Hill Top Farm,
Eastfield Lane,
Thurgoland,
S35 7AY.

Ref: Conversion of agricultural buildings to provide accommodation:
Unit 1 and Units 2 - 5.

This supplementary report follows receipt and review of drawings from Ibbotson Architects which illustrate the layout of the proposed units. Also, preliminary calculation in which I assess the loads which will be imposed on the structure by the proposed alterations. I deal with the main elements of the structure as follows:-

| TITLE:<br><br>Proposed Layout<br>Residential Units                                                                                                                                                                   |          |        |

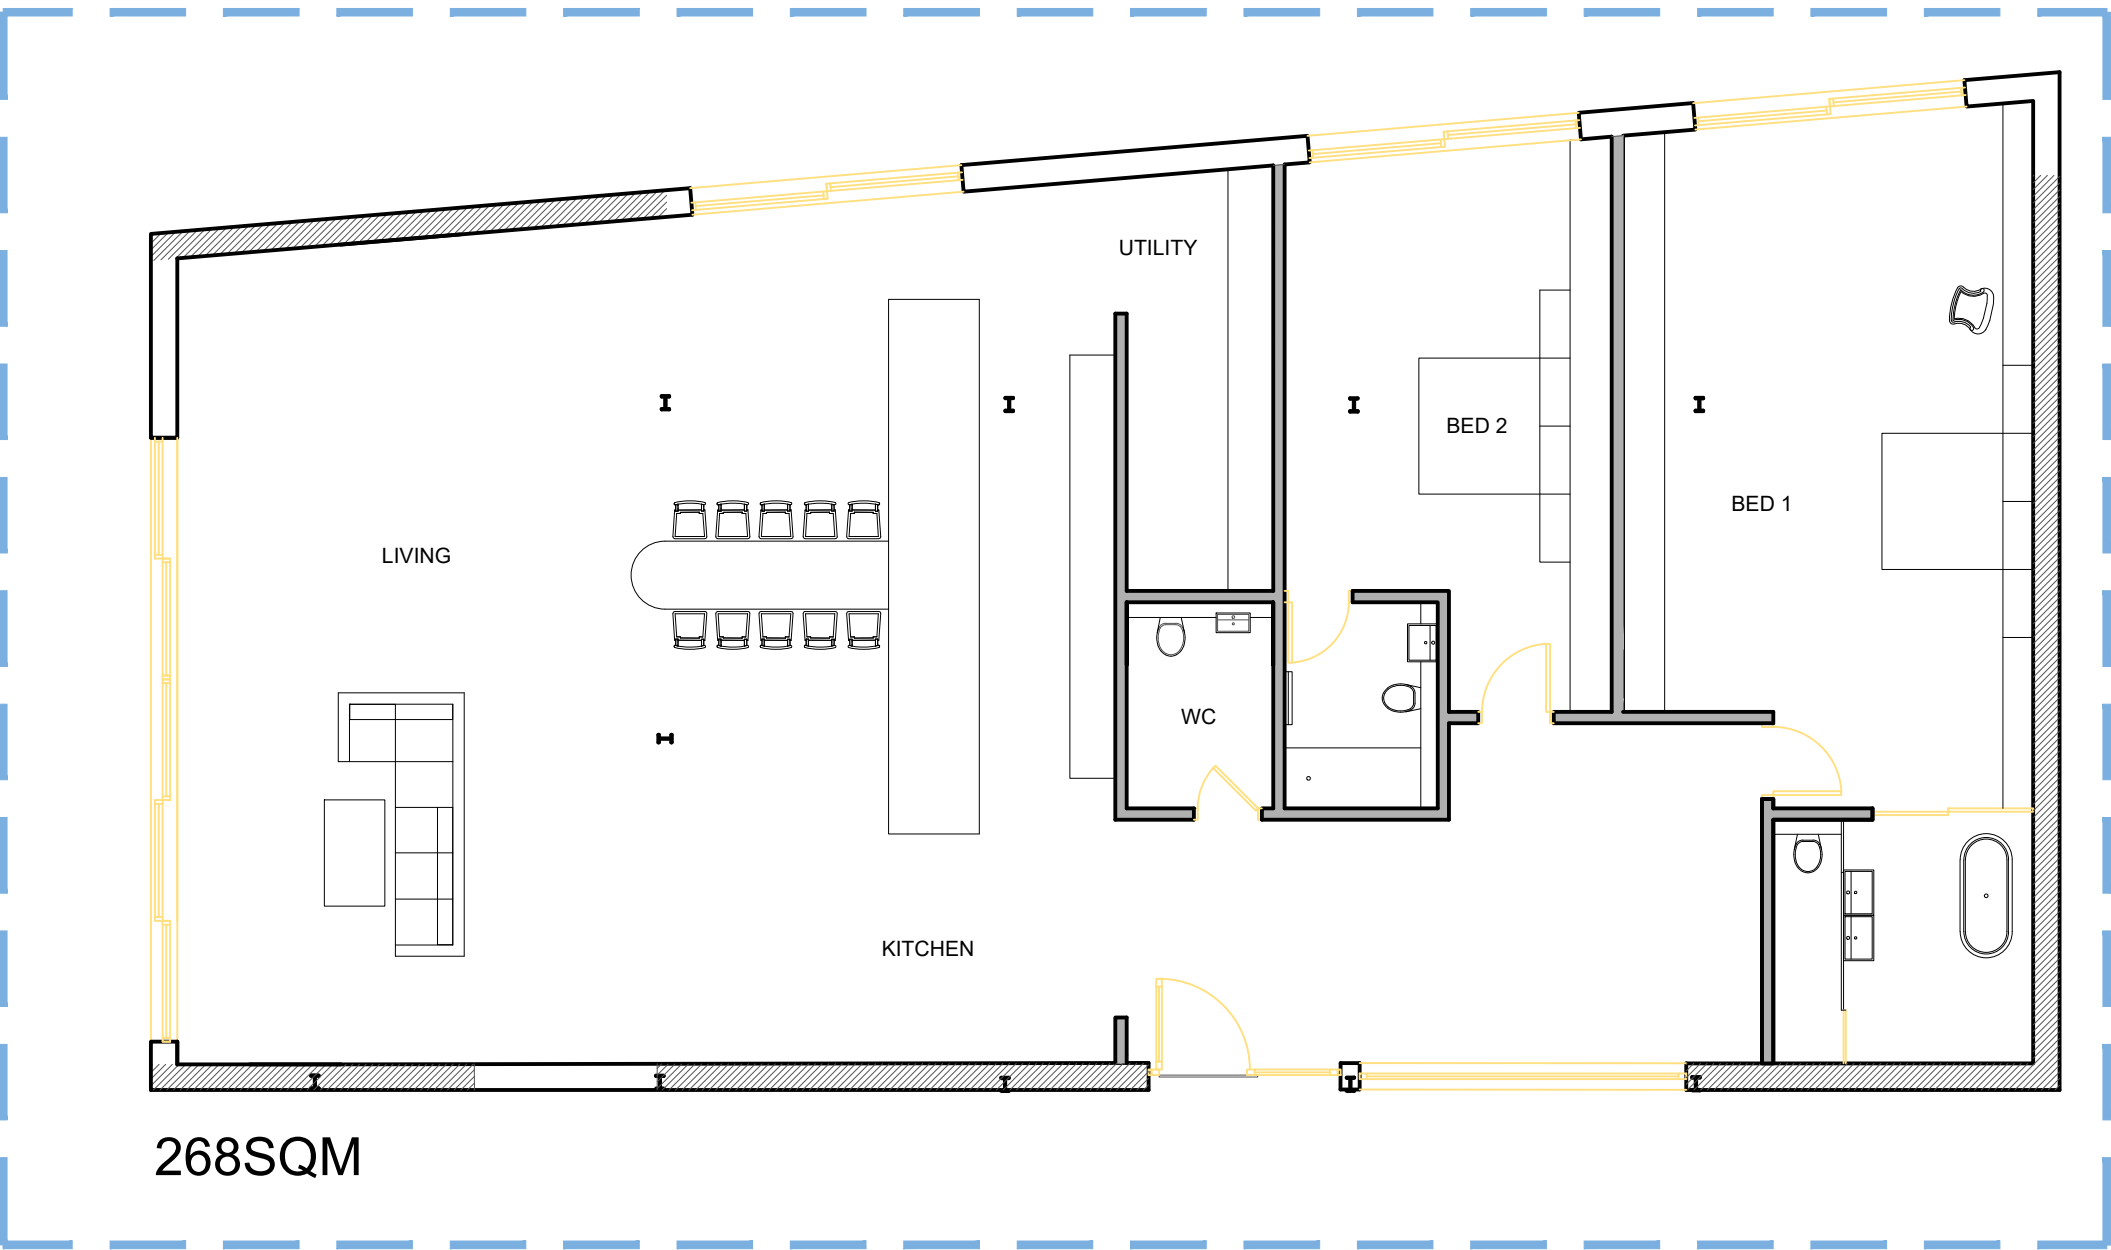
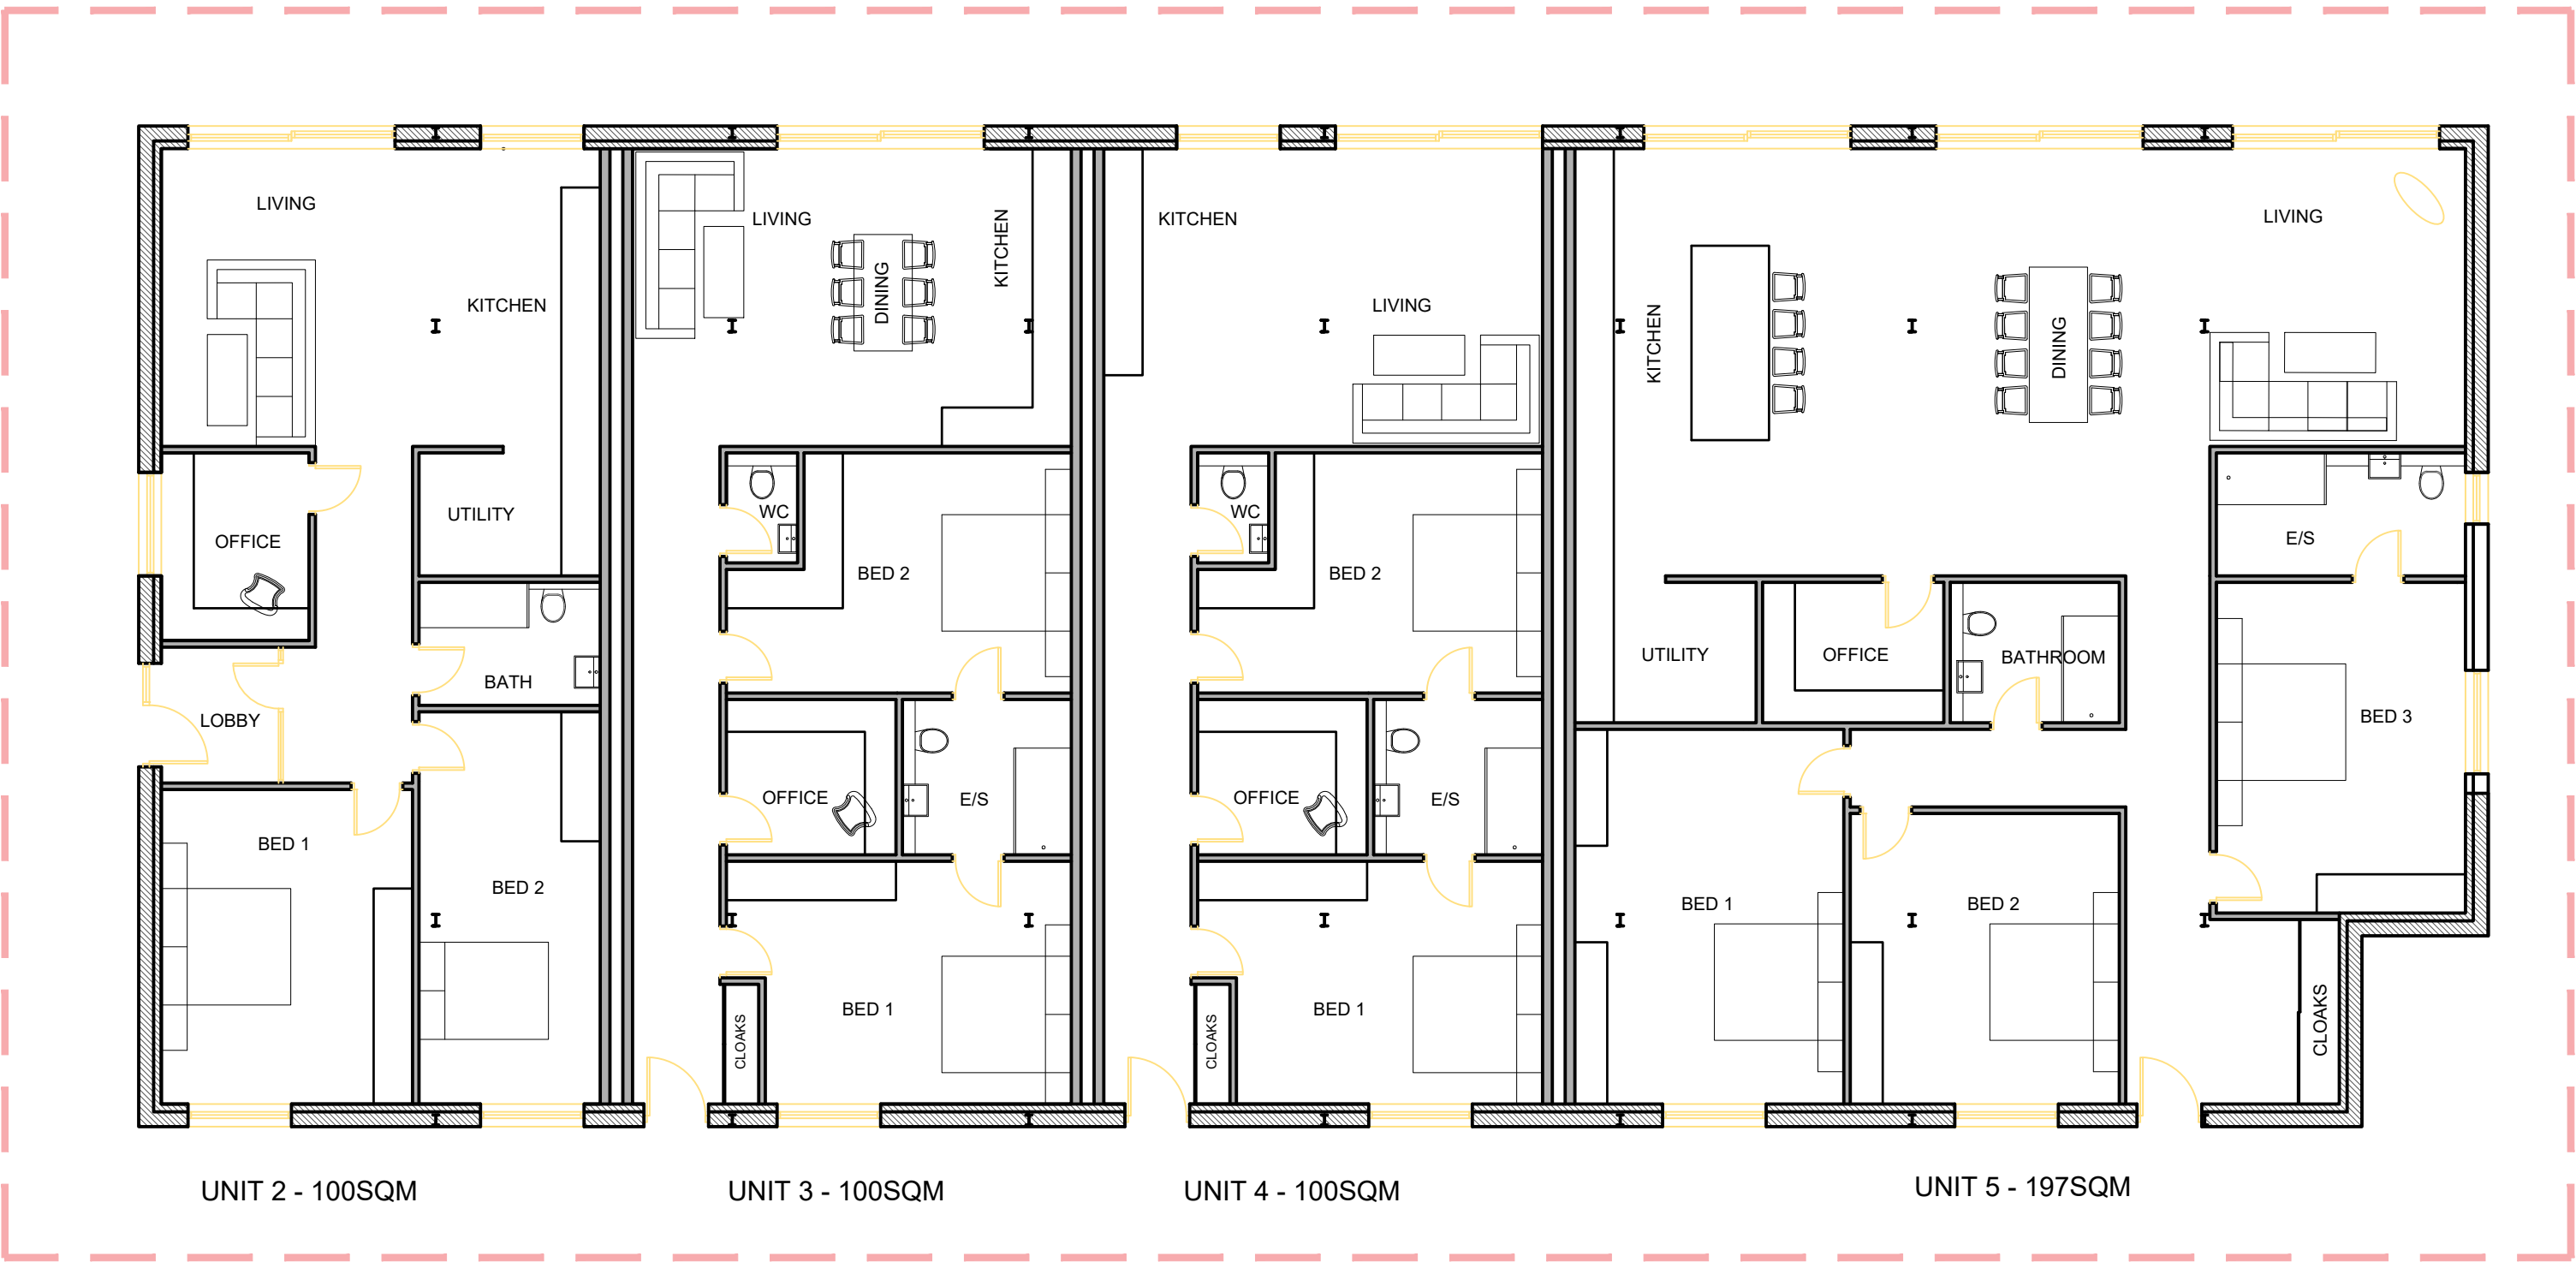
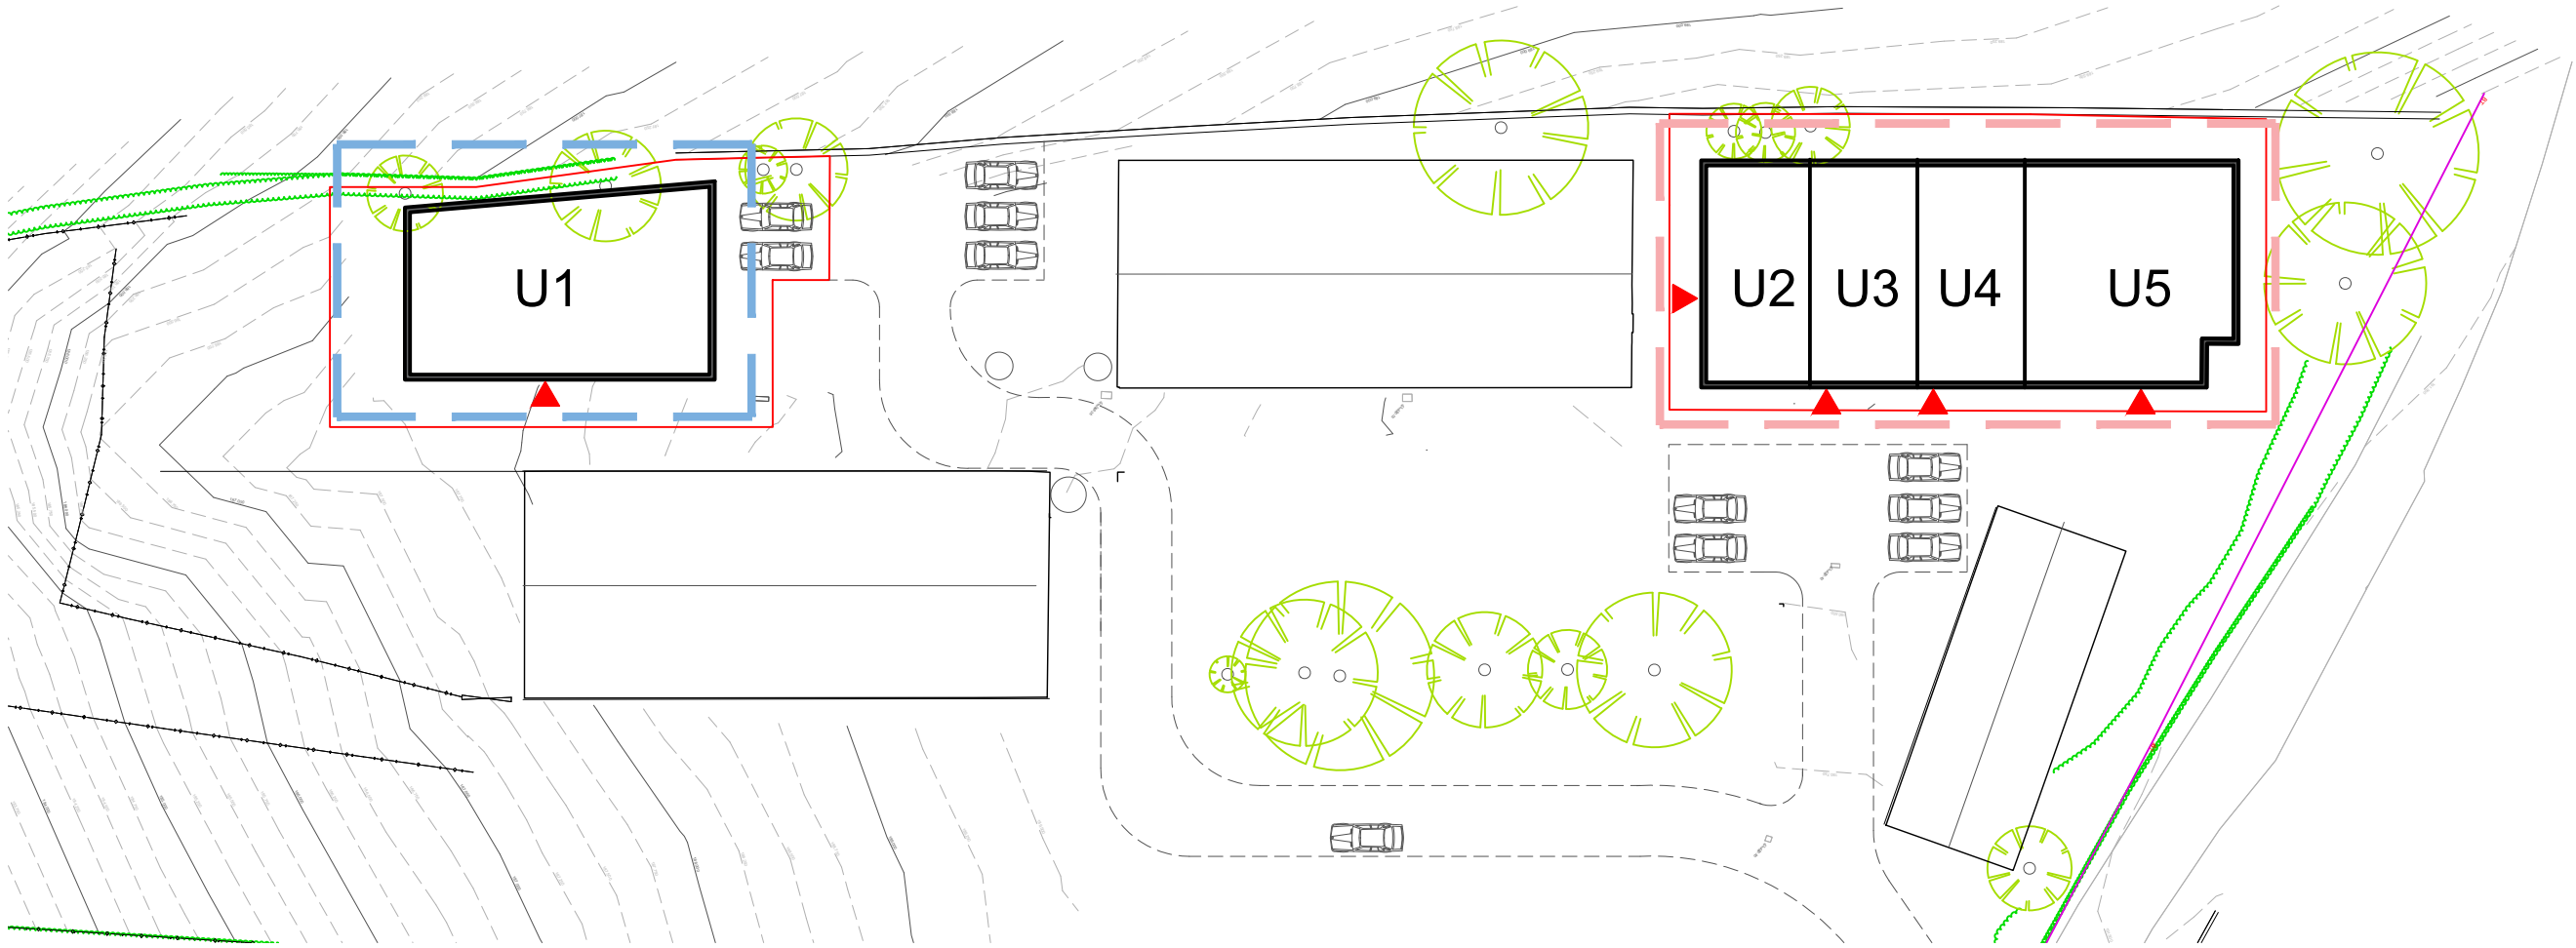
Floor Slab: It is my opinion that the existing floor slab will provide suitable support for the lightweight blockwork partition proposed.
